Rezoning Transportation Analysis

Petition Number: 2023-089

Date	Description
9-28-23	Review (IW)
12-19-23	Second Review (KC)

RZ-1.0

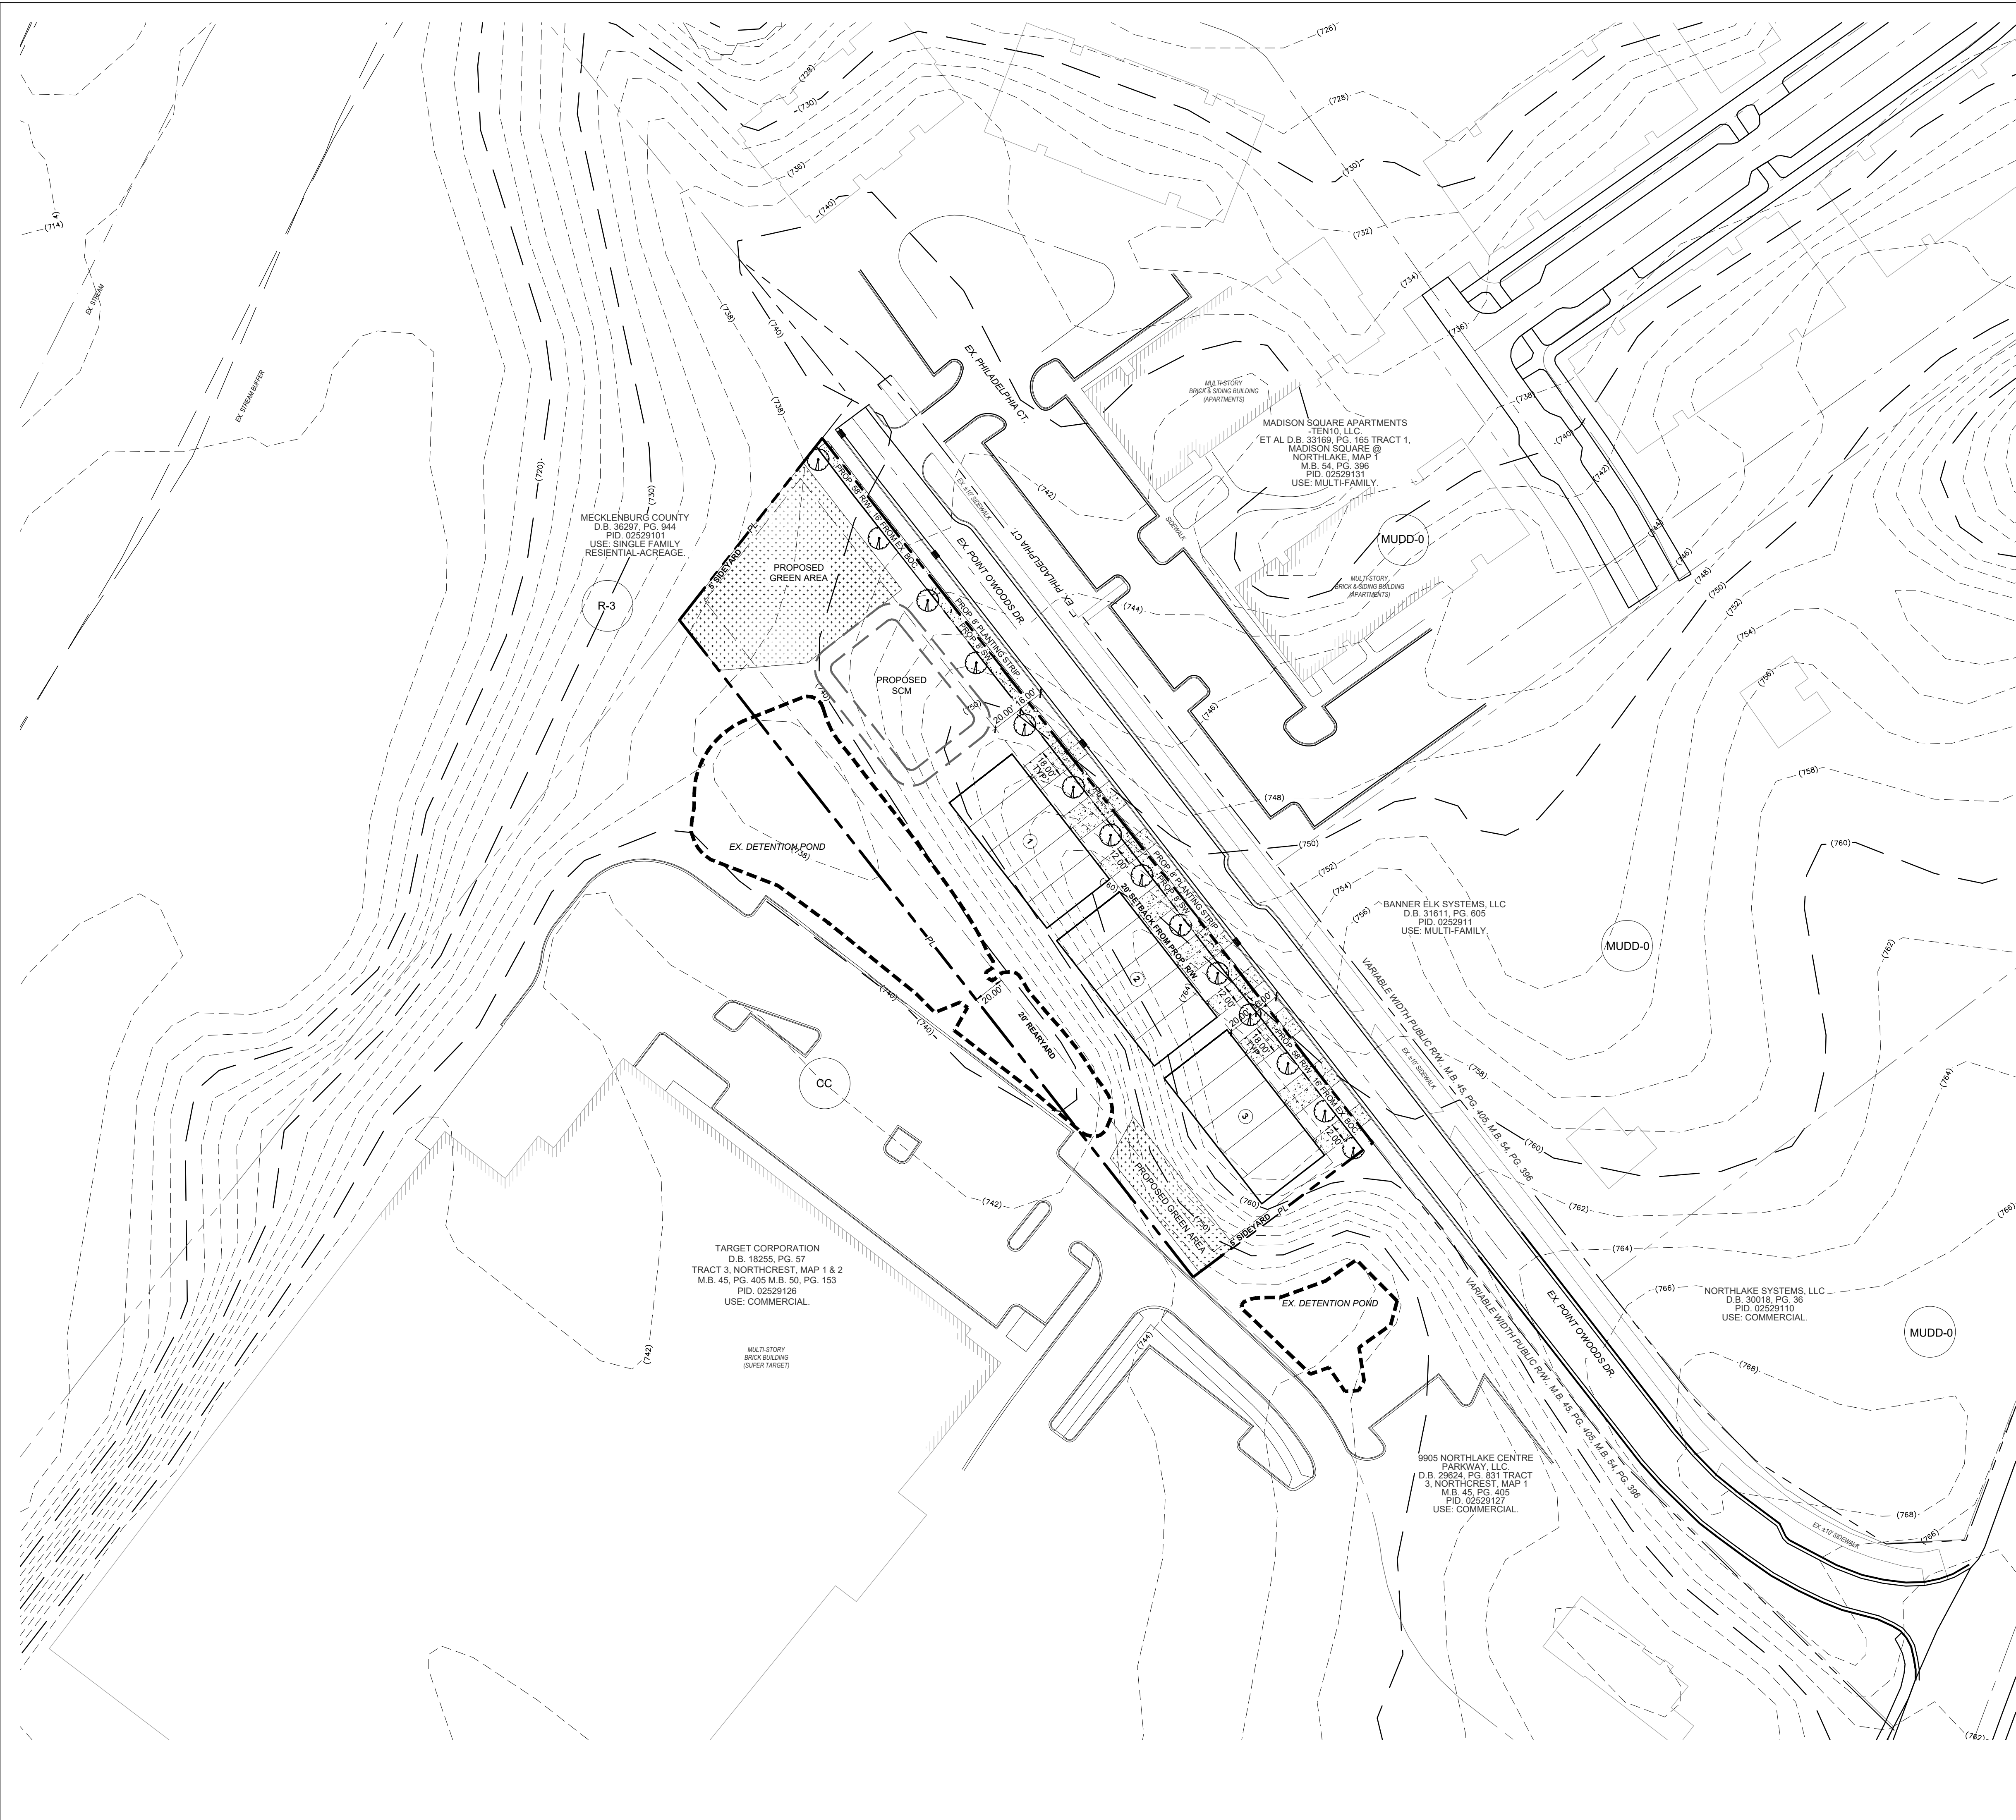
~~6. Revise conditional note 5.d. to commit to an 8' Planting Strip and 8' Sidewalk instead of the 6' Planting strip and 5' sidewalk stated in the note.~~

RZ-1.0

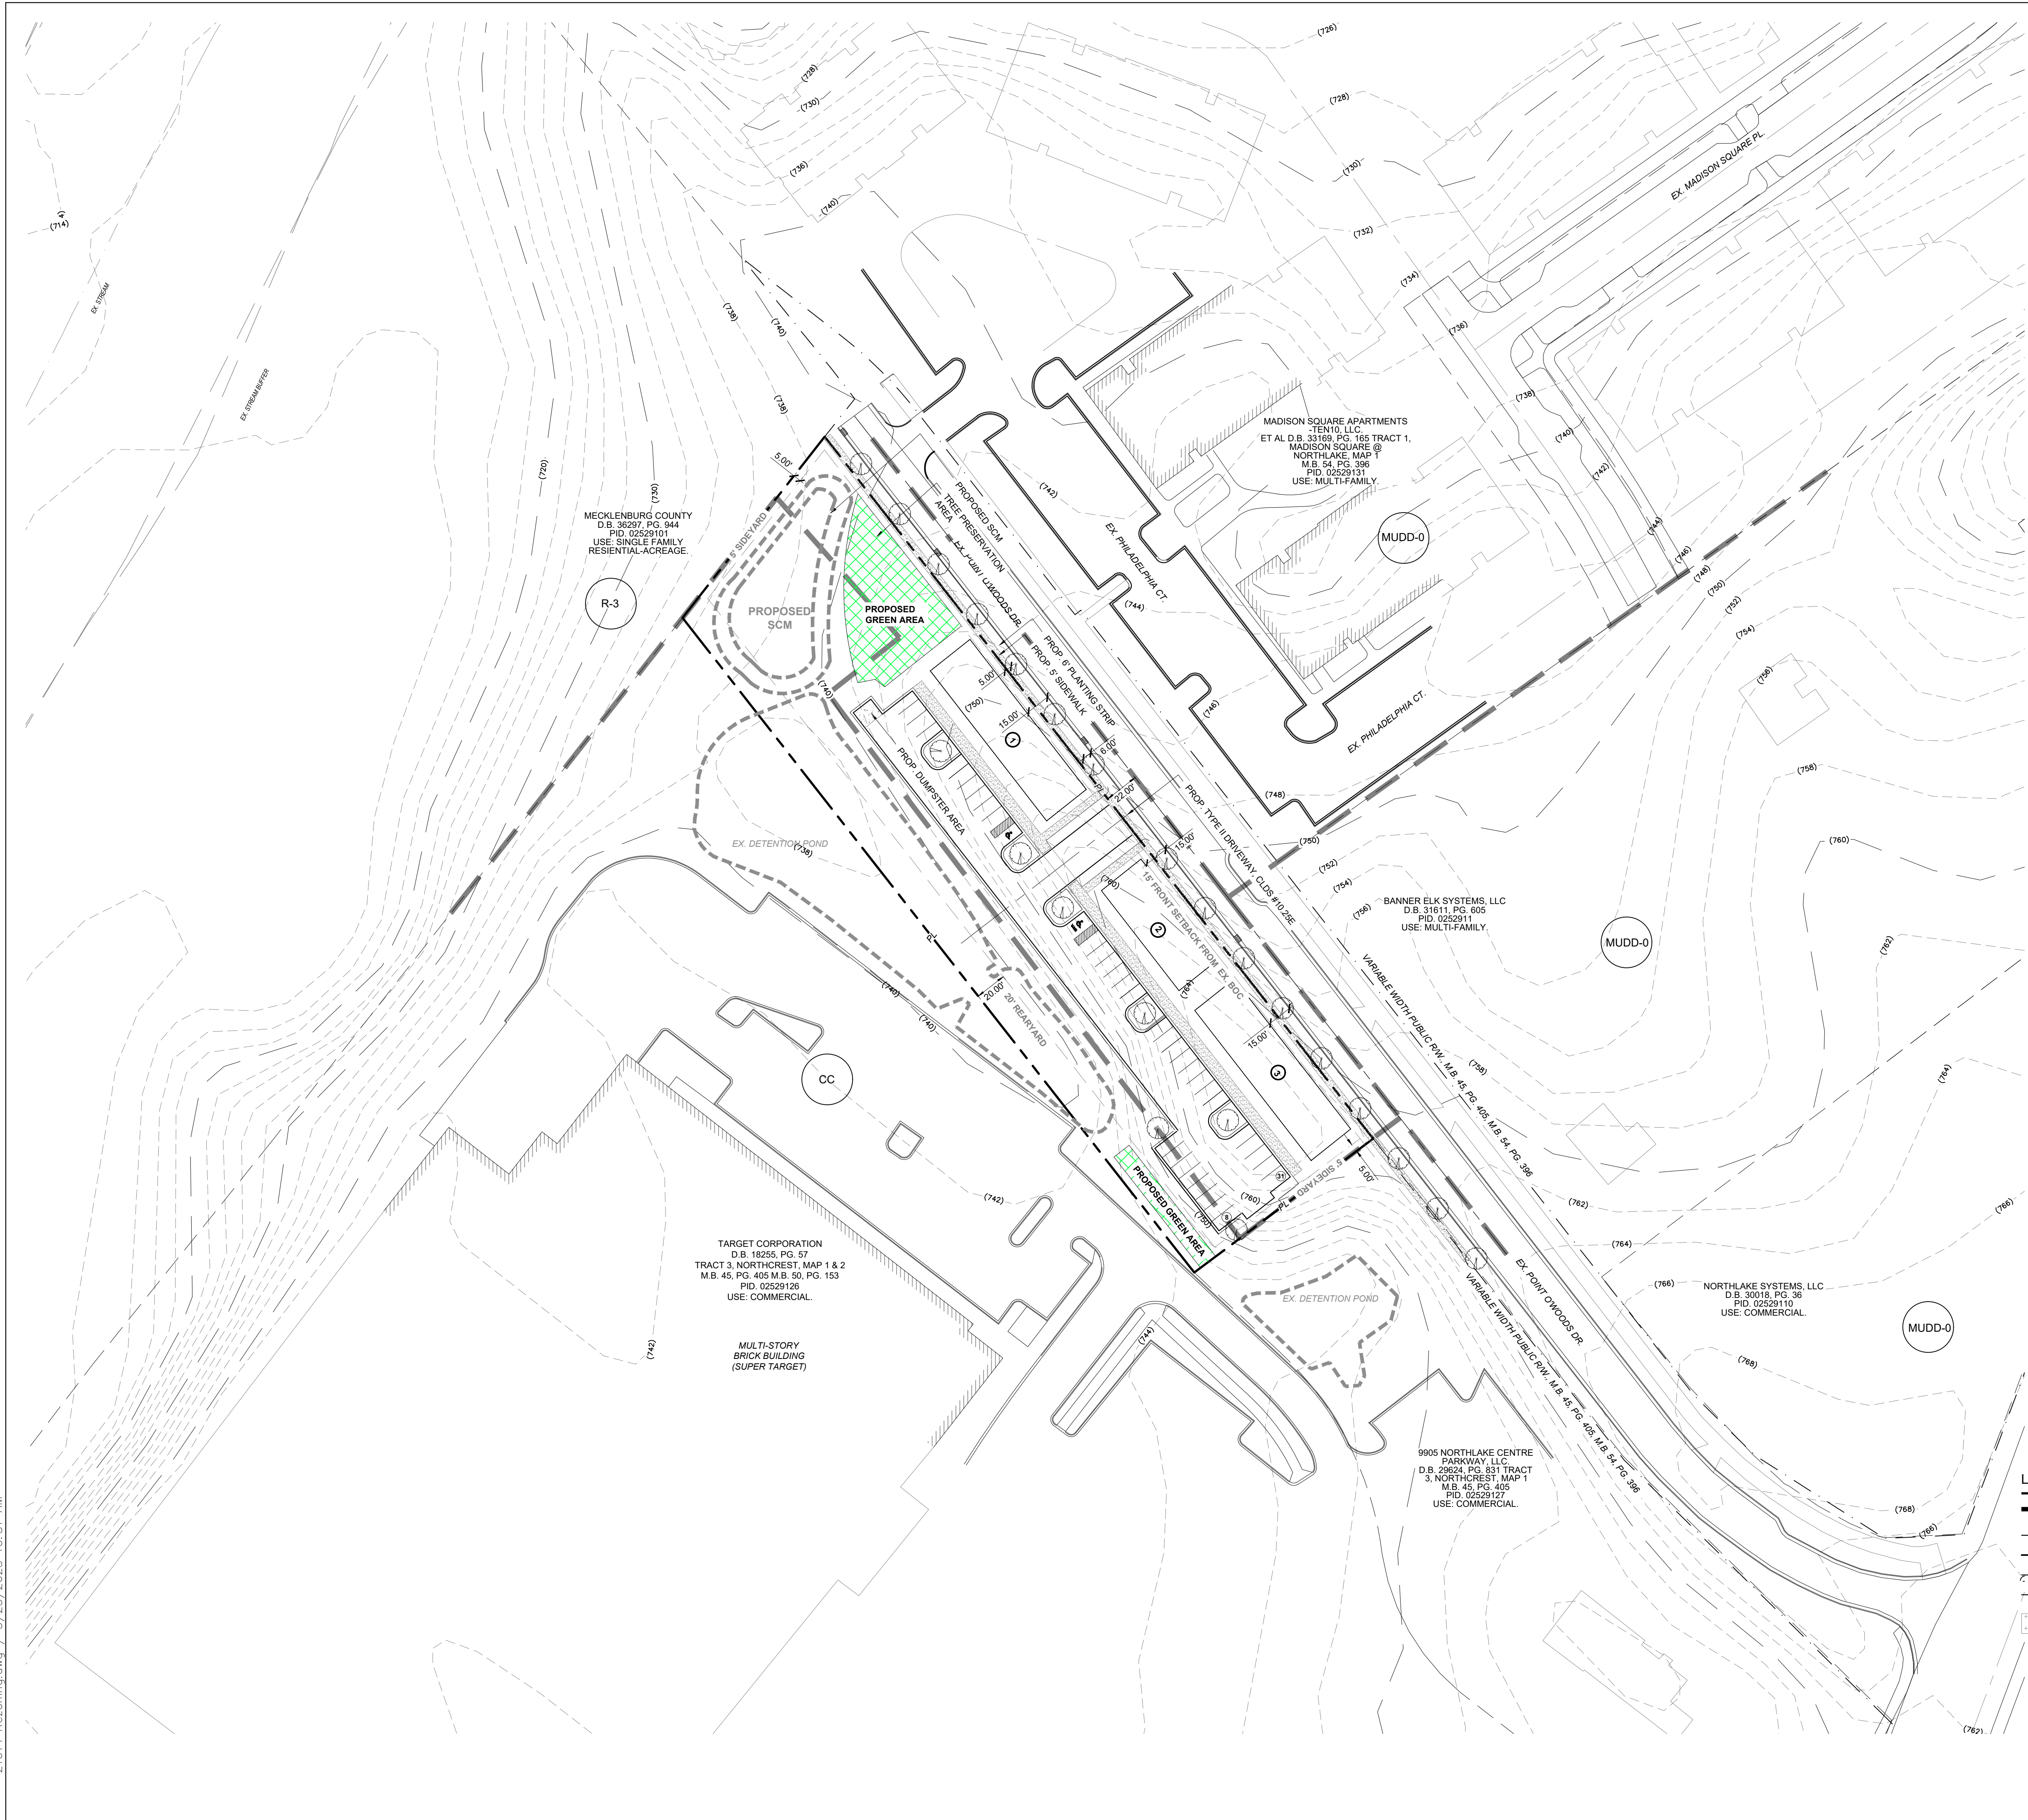
~~Label and dimension the curb and gutter from the centerline for each road on the site plan.~~

~~3. Revise site plan and conditional note(s) to commit to dedicate 27 feet of right-of-way from the road centerline. The site plan shall label and dimension the right-of-way from the road centerline.~~

~~5. Revise site plan and conditional note(s) to commit to installing an 8' Planting Strip and 8' Sidewalk based on Article 33 in the UDO for Neighborhood 2 Place Type.~~
